Vicinity Location Map_V1.pdf Markup Summary

Subject: Text Box
Page Label: [1] VICINITY MAP
Author: Rob Stauffacher
Date: 6/27/2022 8:21:17 PM
Status:
Color: ■
Layer:
Space:

**HIGHWAY 24 & MERIDIAN ROAD
FALCON, CO**

VICINITY MAP

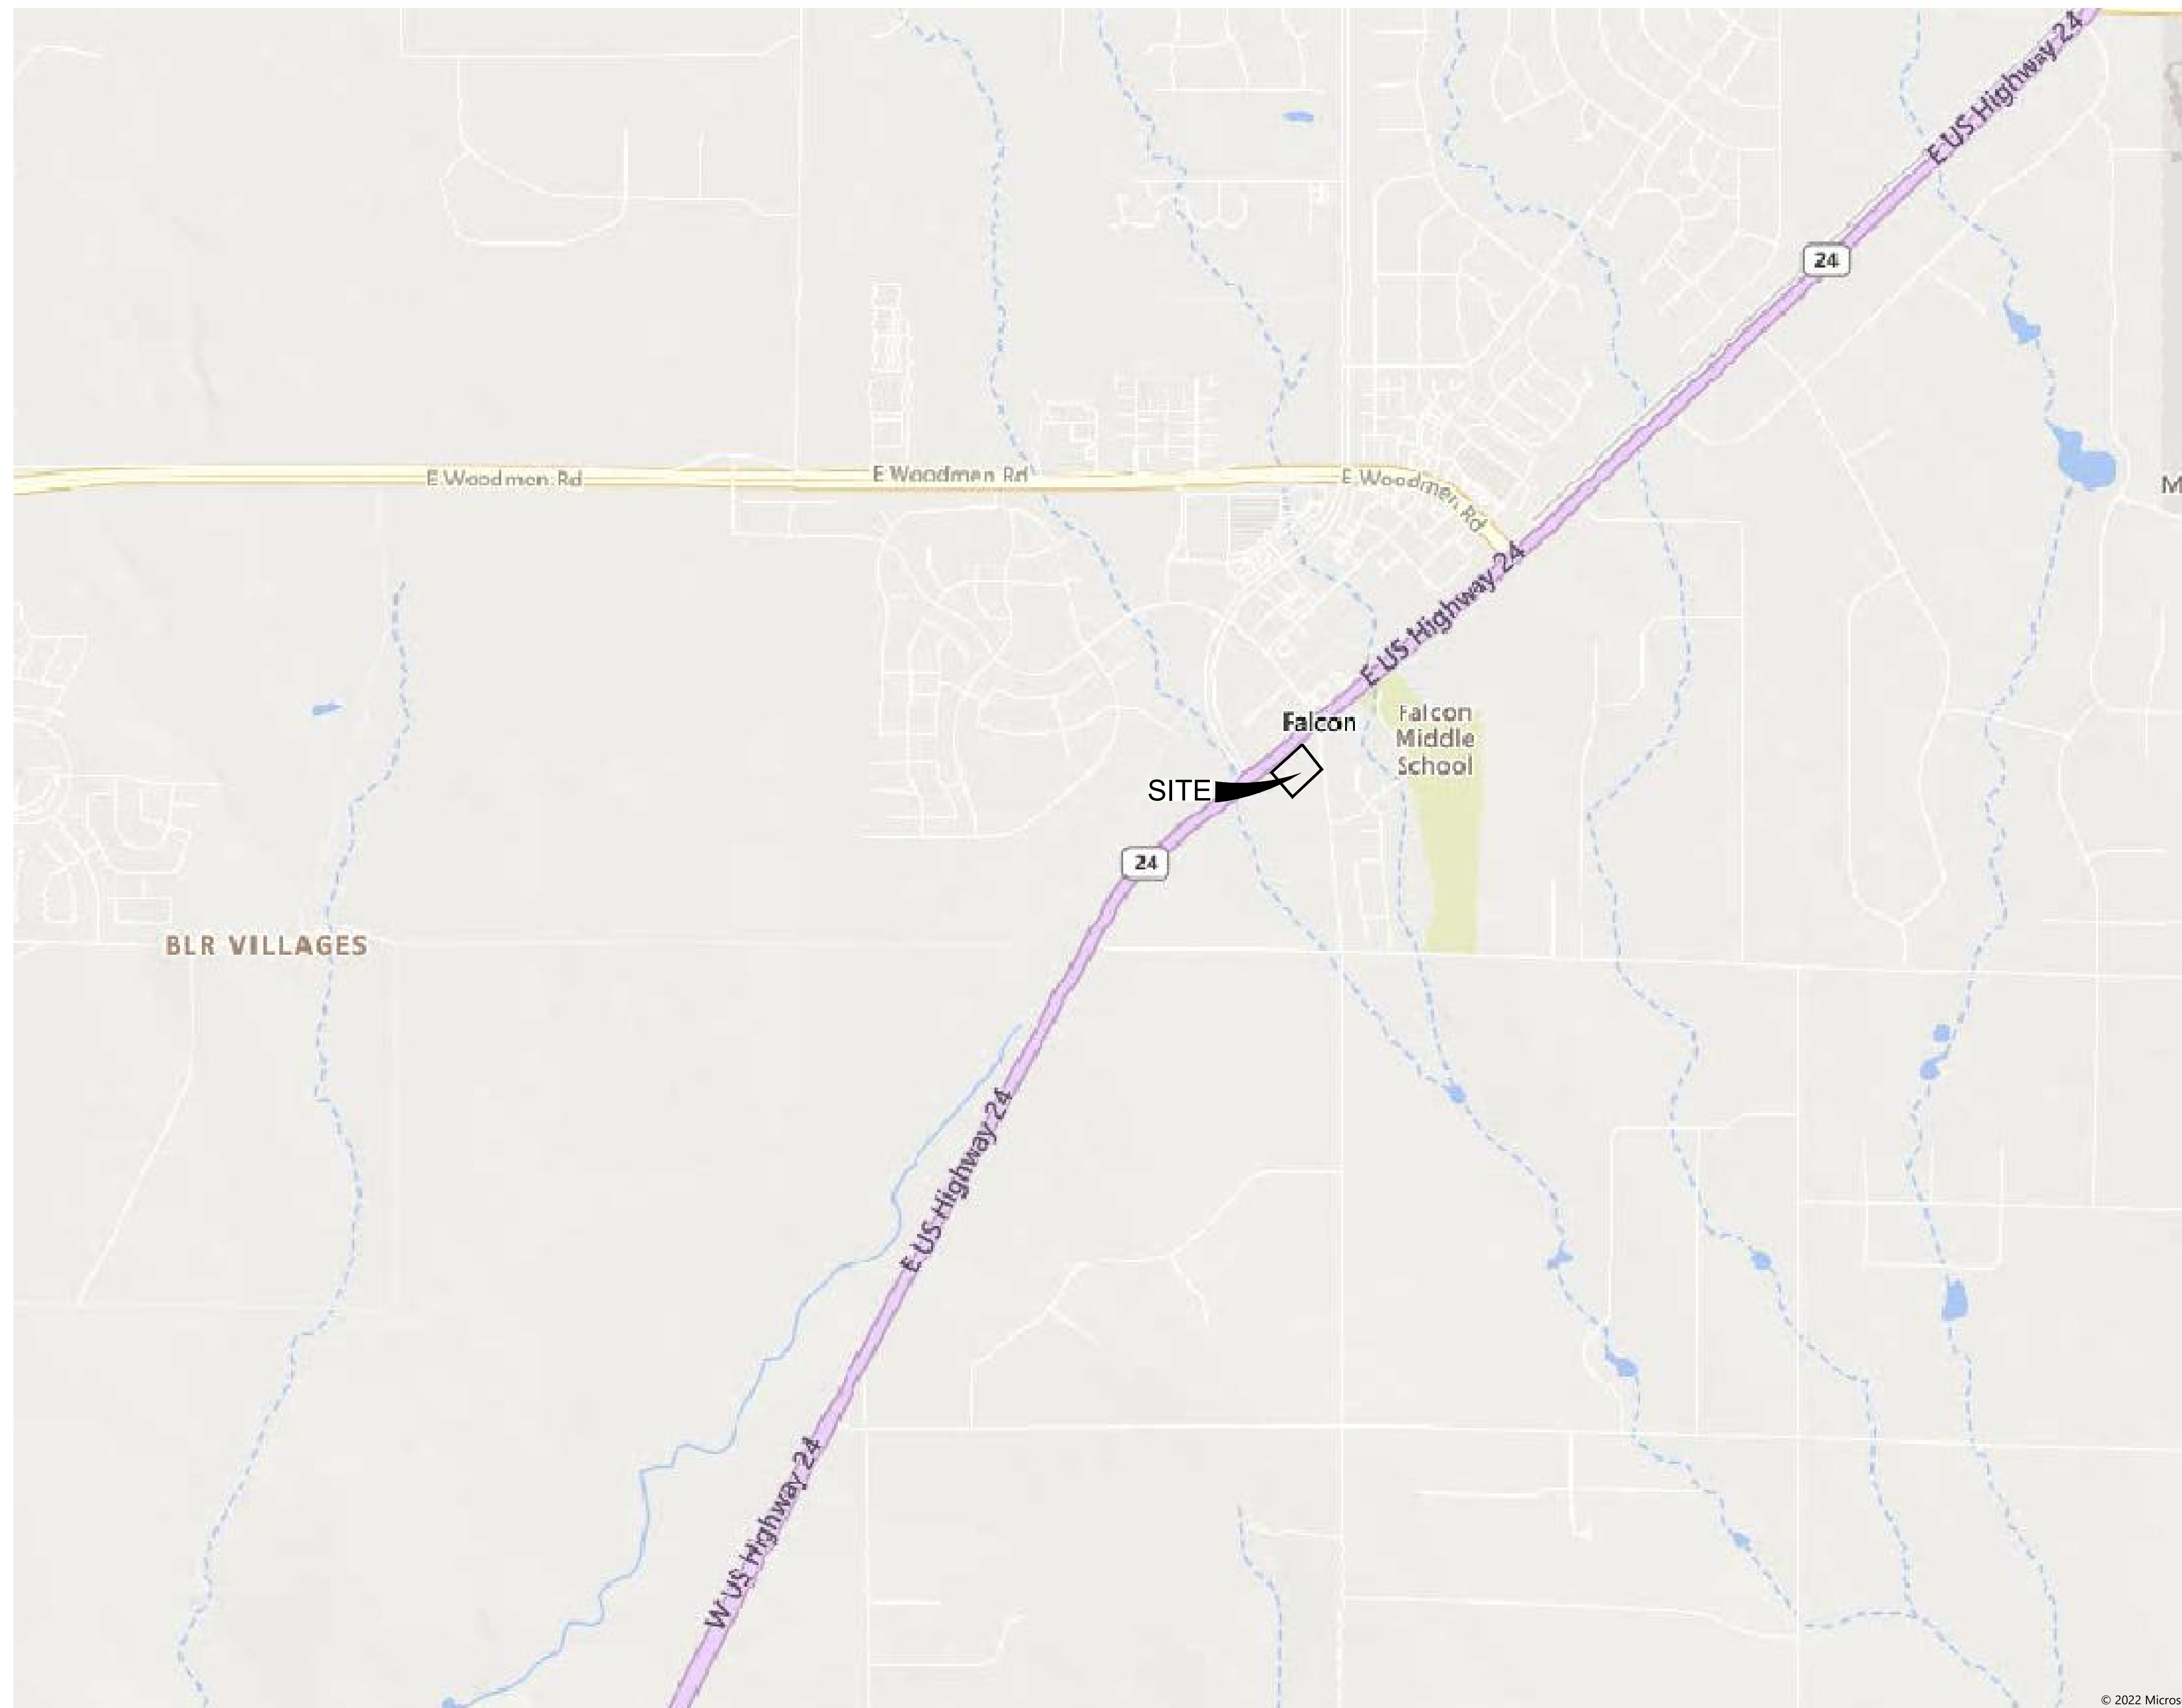
Include owner and planner/plan preparer email addressees.
